CITY OF PORTLAND

BUILDING PERMIT

Job ID: 2012-03-3625-ALTR

has permission to Replace existing porch and add a deck (Single Family Residence).

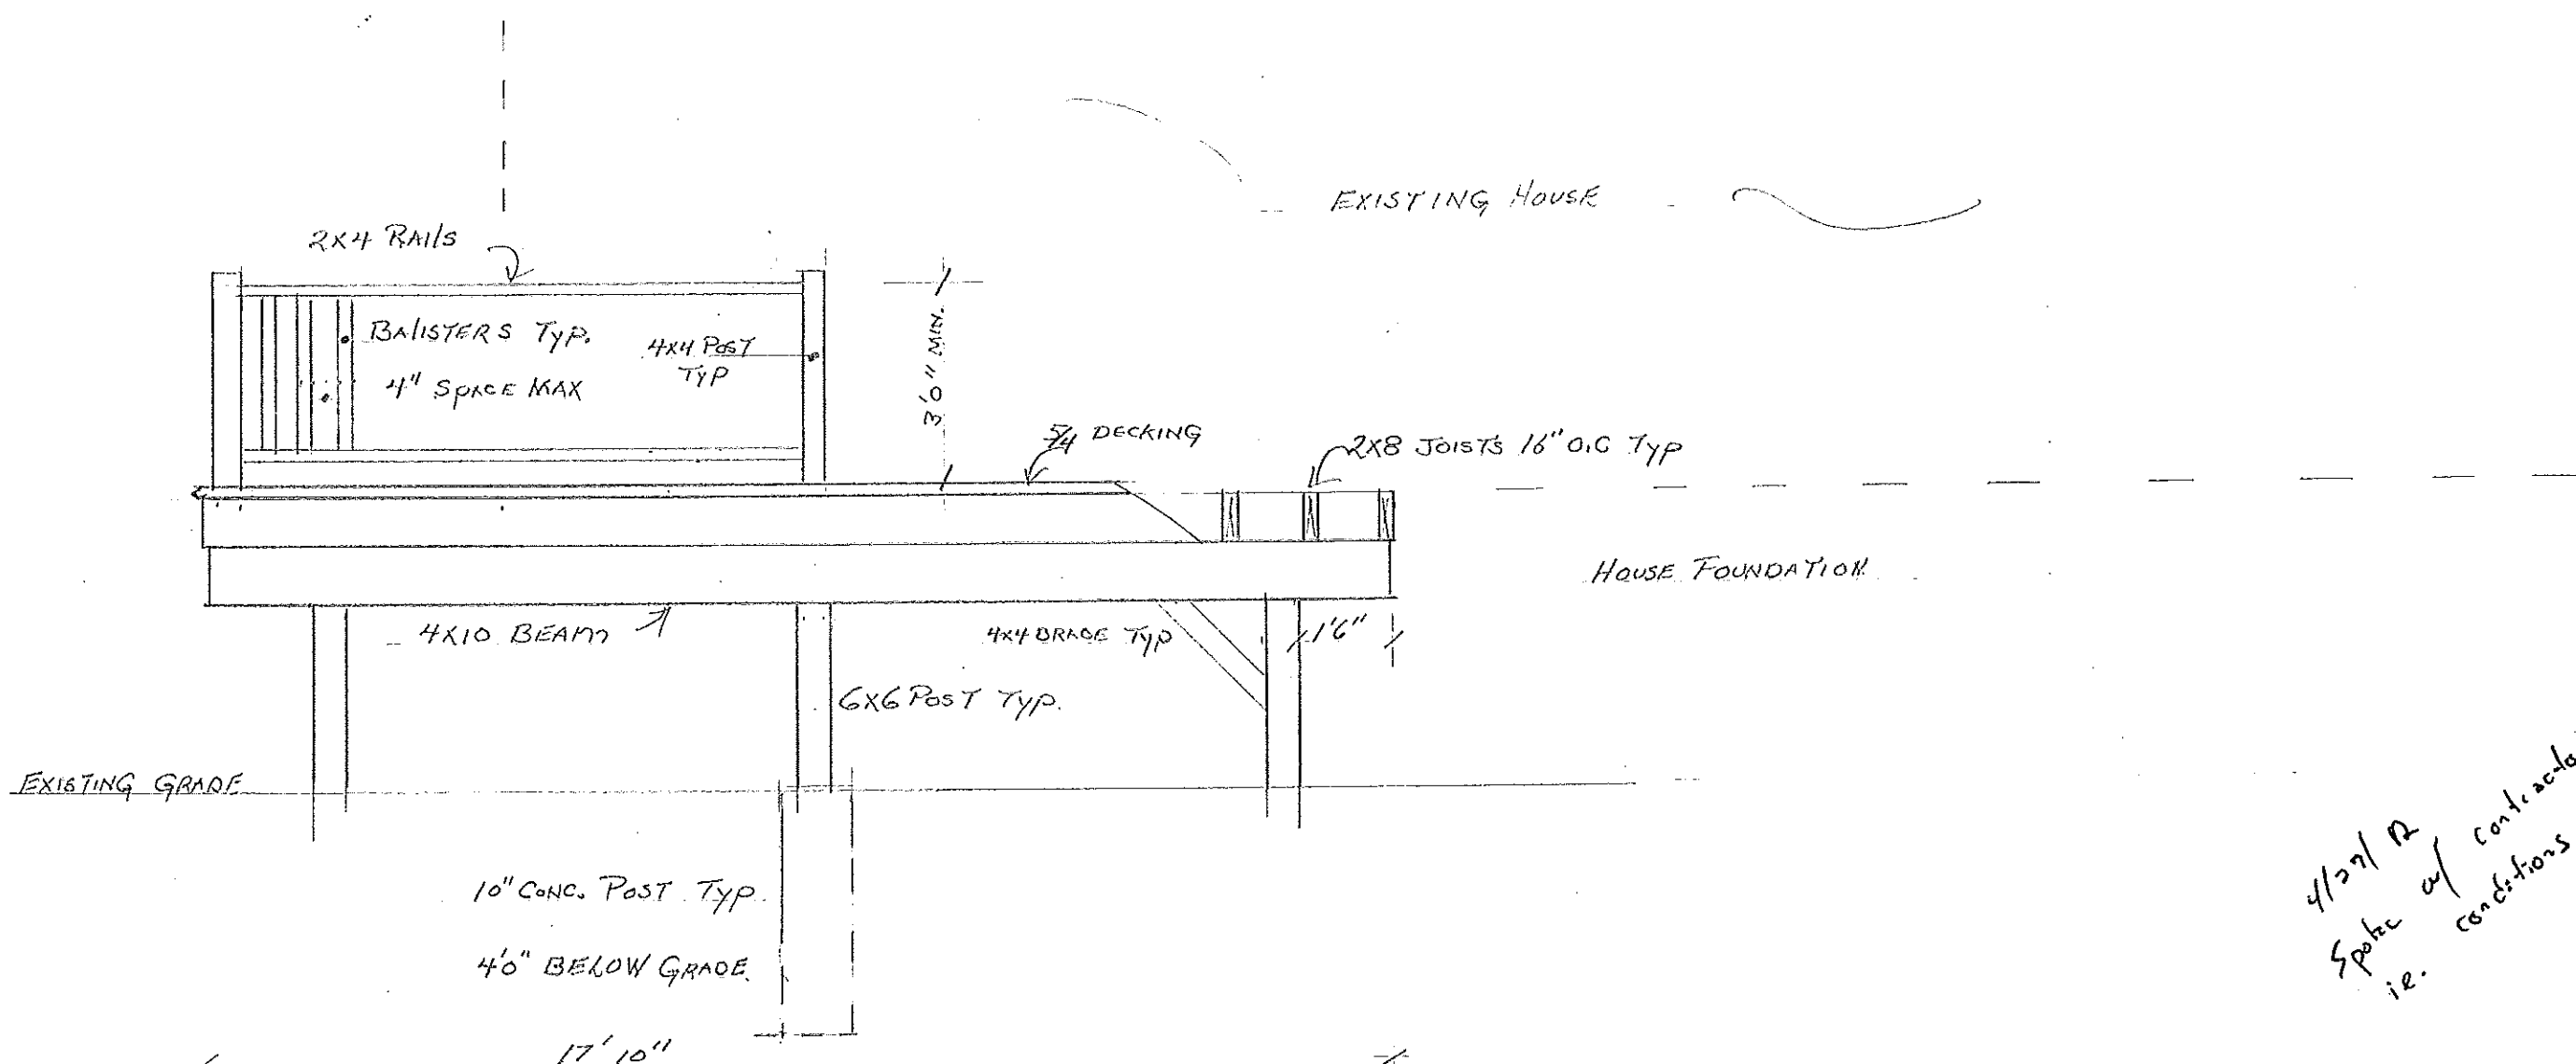
8. For decks with **cantilevered framing members**, connections to exterior walls or other framing members, shall be designed and constructed to resist uplift resulting from the full live load specified in Table R301.5 acting on the cantilevered portion of the deck, see attachment.

9. Note: Max span for (3) 2 x 8 inch beams will be **7 foot 5 inches** and the (2) 2 x 10 inch beams will span 7 foot 3 inches between each 10 inch concrete post.
